Air Quality Review: West Midlands Interchange

December 2018

- 1.1 Air Quality Consultants Ltd (AQC) has reviewed the information submitted in relation to air quality in support of the DCO application for the West Midlands Interchange.

- 1.2 This report reviews chapter 7 of the Environmental Statement and associated appendices (hereinafter referred to as the “assessment”).
- 1.3 This review has been carried out on behalf of South Staffordshire District Council (SSDC). It focuses on the potential impacts of the development on local residential properties and nearby designated ecological sites within South Staffordshire. This review covers the following issues:

Figure 7.2.7: Comparison of final modelled NO₂ with Measured NO₂ in South Staffordshire

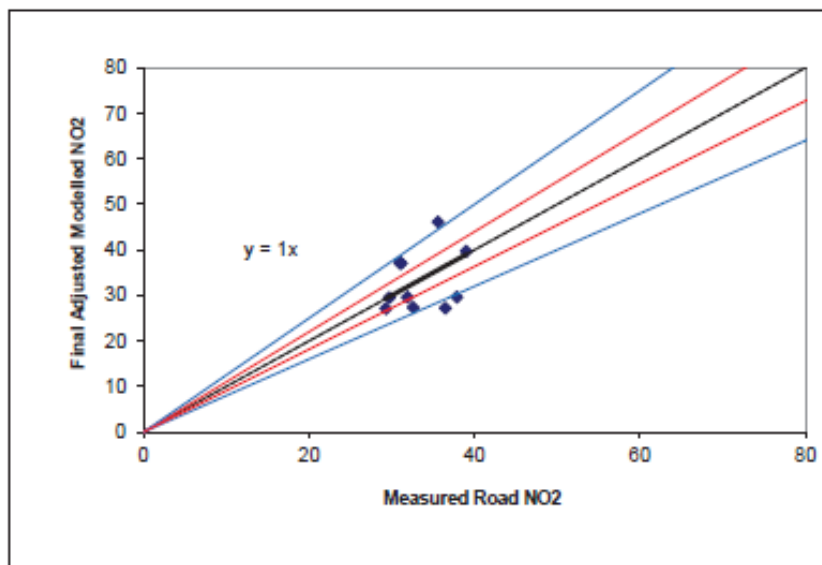
- 3.6 However, as shown in the Figure below (reproduced from the assessment), there is a large amount of scatter in the model results when they are compared with the measured values. At three of the sites, the final NO₂ concentrations fall outside the Defra guideline of +/-25%. In addition, the scatter suggests a very poor overall relationship between modelled and measured concentrations. As the actual predicted and measured values are not stated, it is not possible to evaluate the model performance against the criteria for R², RMSE and FB, as stated in LAQM.TG16; these data and calculations should be provided.

- 3.7 No model results are presented for the baseline year and it has not been possible to make a direct comparison with measurements and model predictions in the same year (other than the data points shown in the Figure). However, the results presented in Table 1 demonstrate that the predicted 2021 results at the monitoring sites (and therefore receptors) alongside the M6 are clearly too high. This is particularly apparent as 2021 concentrations would be expected to be lower than 2016 values, and in this instance they are higher.

- 3.8 As the 2015 baseline model results are not presented, it difficult to determine the extent of any under-prediction of the model at the other monitoring sites. This is particularly important for HA2 within the AQMA, which will be most sensitive to any changes in concentration as a result of the development. This may have resulted in the changes in concentrations being under-represented and could invalidate the reported conclusions.
